CITY OF PORTLAND

May 25, 2001

RE: 105-107 India St. (020 A008)

With regard to your waiver request dated 4/12/01, the following is the disposition:

REVISED 1<sup>ST</sup> FLOOR PLAN

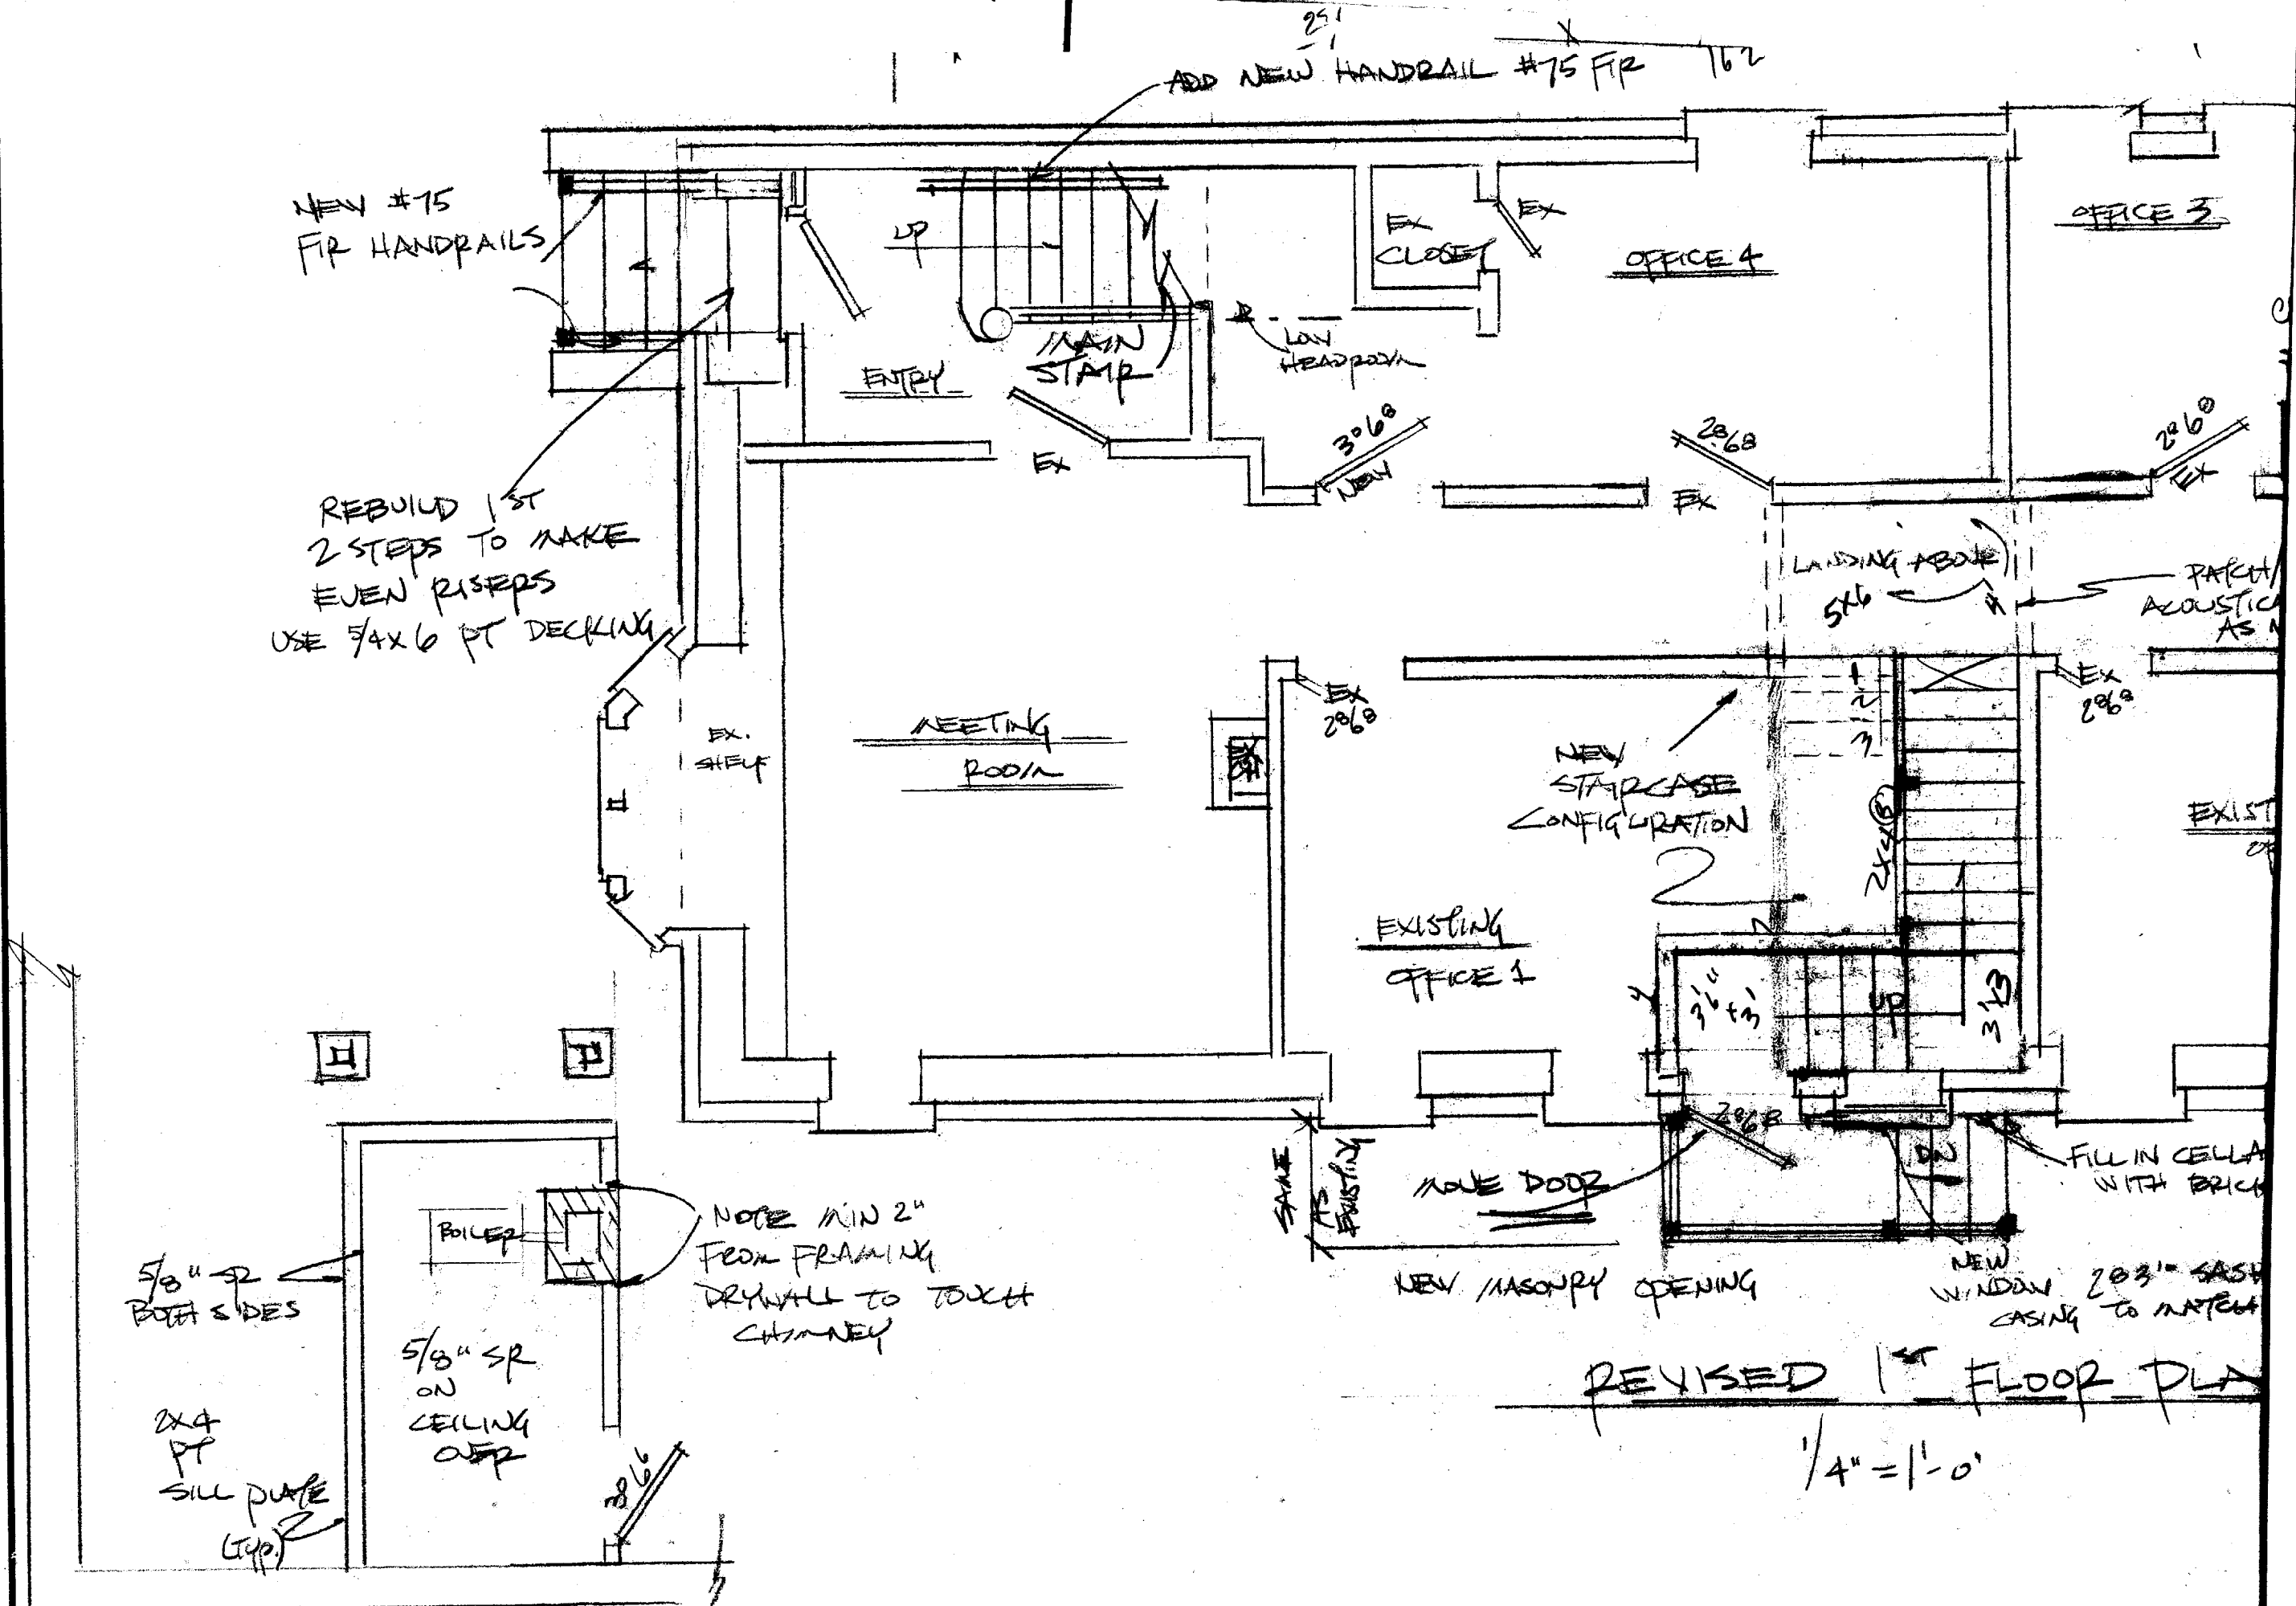
Request # 2. Headroom adjustment in the 1st floor office hallway of 6 10 for an area 12 X 17 is approved.

STAIR SECTION  
1/2" = 1'-0"

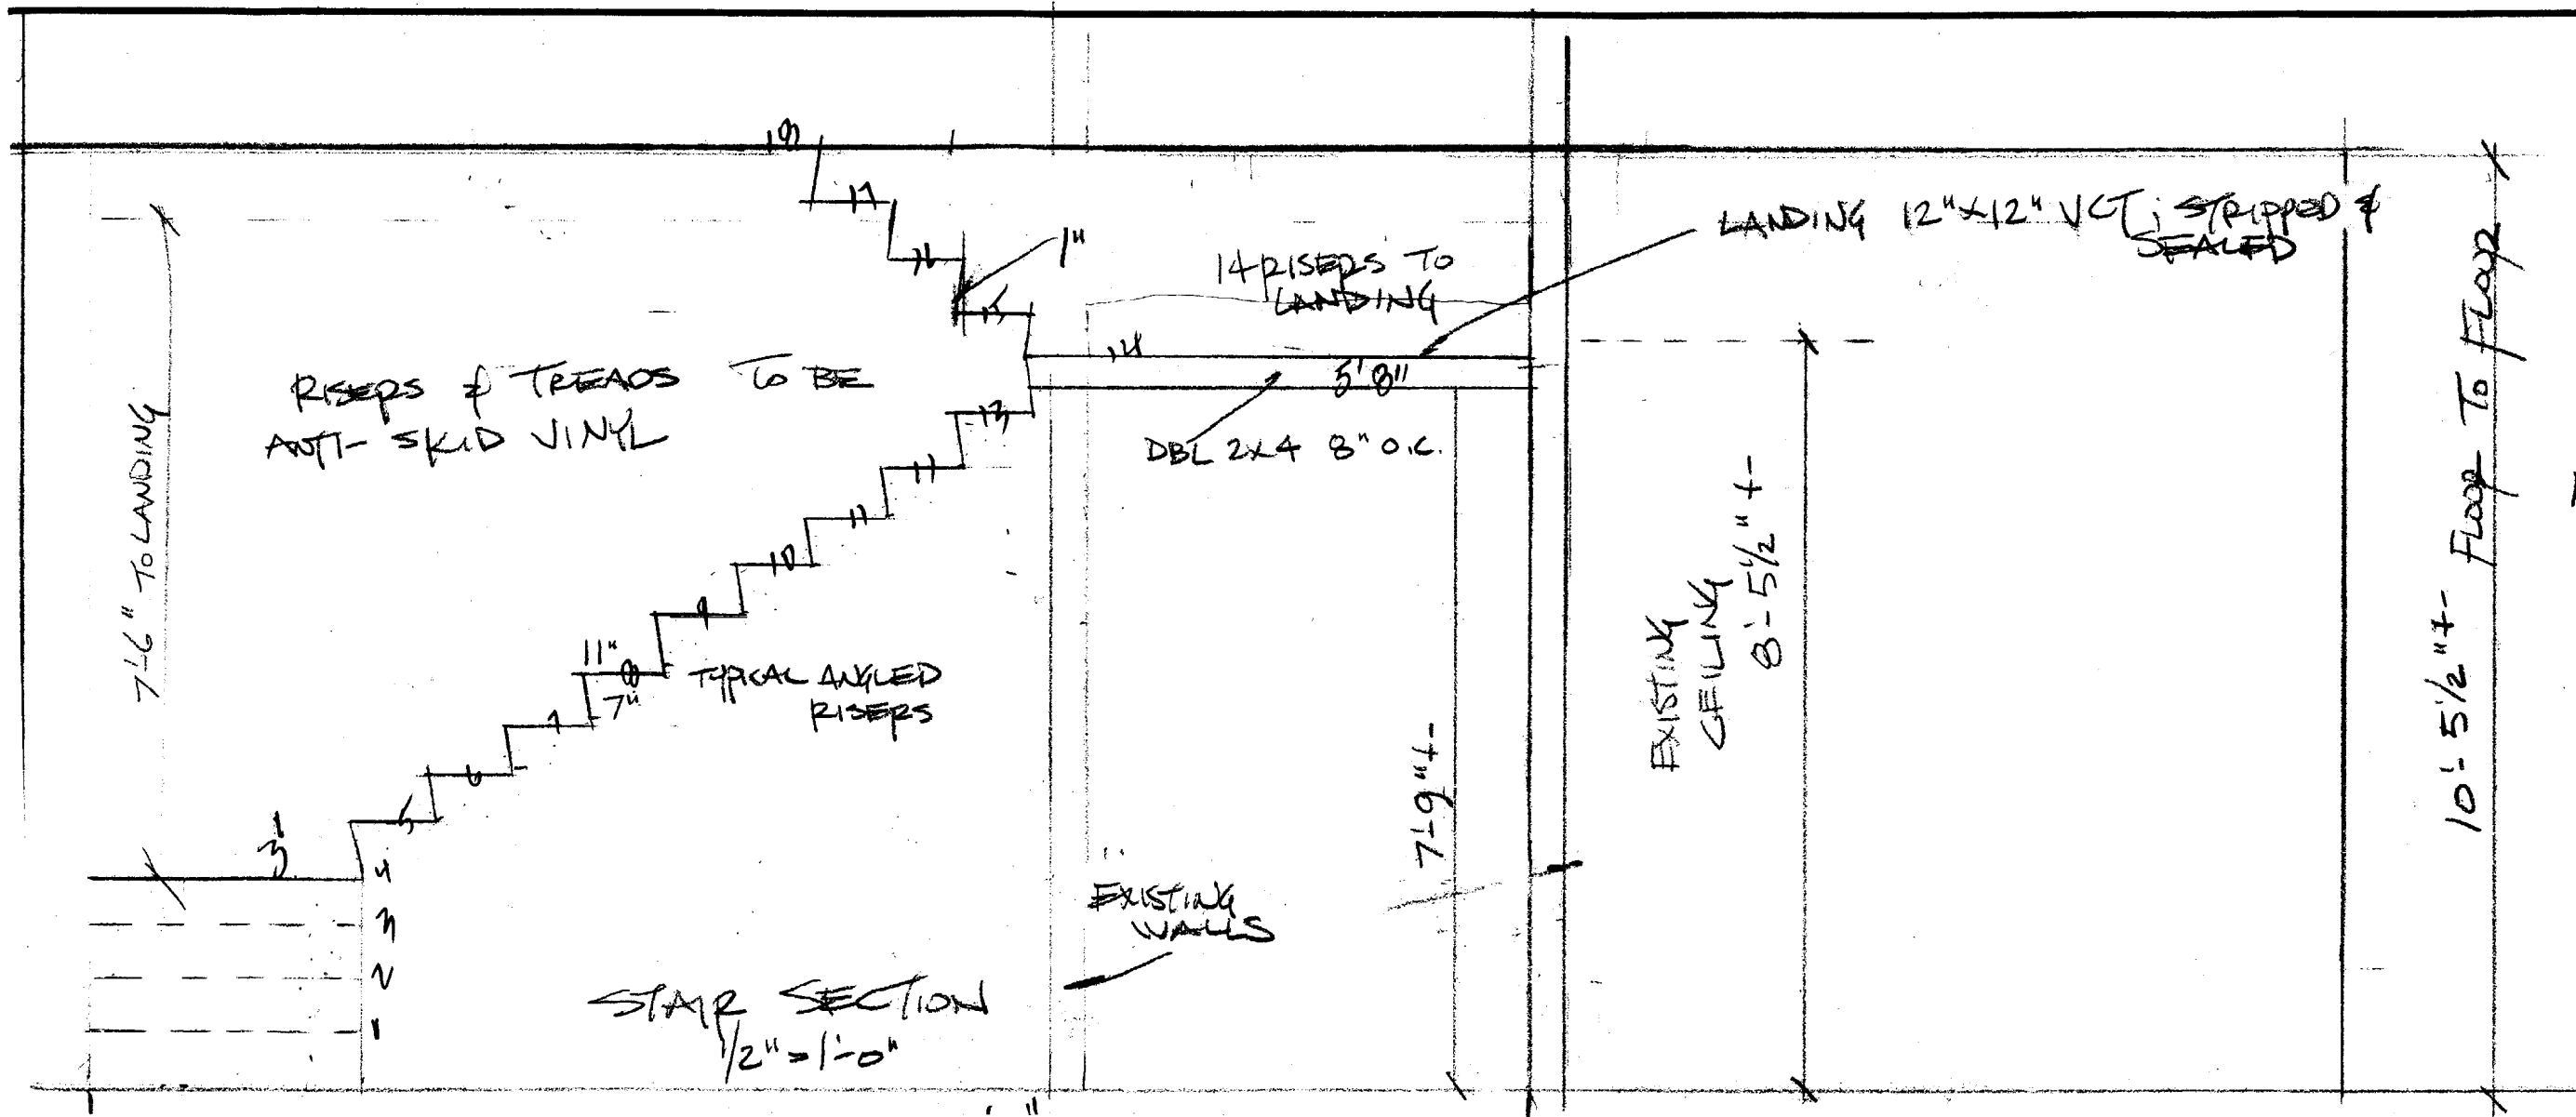
Request # 1. Handrail Extension at 2 inches beyond the bottom riser is approved as the railing would terminate into a doorway at required 11 inch termination. The 2 rail must return to the wall as required by Code.
